Design and Access Statement Appendix A

Design Analysis of alternative siting of dwelling

New Passivhaus dwelling at Tower Street, Barnsley which is accessible and adaptable to the requirements of M4 Category 2

1. **PLANNING RESPONSE TO APPLICATION REF: 2024/0112**

Drawing
Rendered street elevation window study

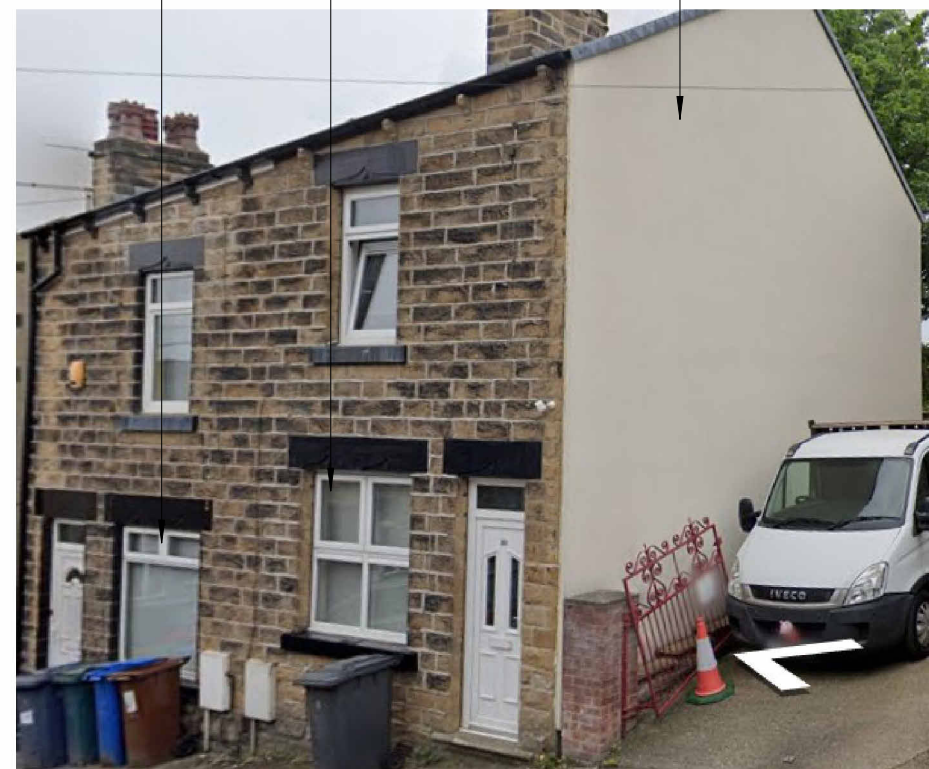
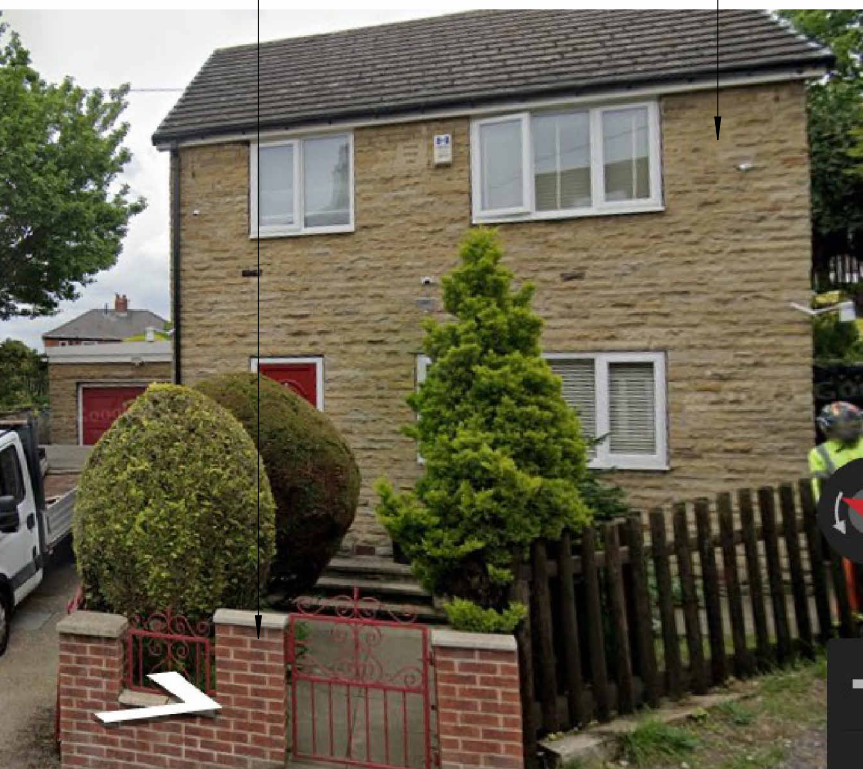
In response to the points raised below, whilst I recognise the applicant's desire to construct a more contemporary and eco-friendly style dwelling, I am not convinced that this is appropriate at the application site. I still consider that the frontage needs to have a more traditional appearance. Although the door is positioned to face Tower Street, this elevation lacks interest and appears fairly blank consisting of just 1 narrow window. This fails to reinforce the local characteristics or appearance of the street

scene. I would strongly advise that the orientation of the dwelling is revisited so the dwelling follows the established street pattern.

We have revisited the design of the street elevation, and we believe that the drawing shown above clearly demonstrates how comfortably the proposed dwelling sits within the streetscape. We also demonstrate with the addition of another window to this elevation and an adjustment to the proportions that we have followed the blueprint of the terrace house windows, with stone lintols and cill details as well as proportion. The elevation is further reinforced with a stone boundary wall base, reflecting the stone walls of the townhouse development.

The materials used are natural stone (rather than artificial stone used on the townhouses), a slate roof and more detail has been added around the windows with dressed stone lintols, cills and jambs. We have also previously submitted a study and contextual photos showing how this reflects the openings in the immediate surroundings.
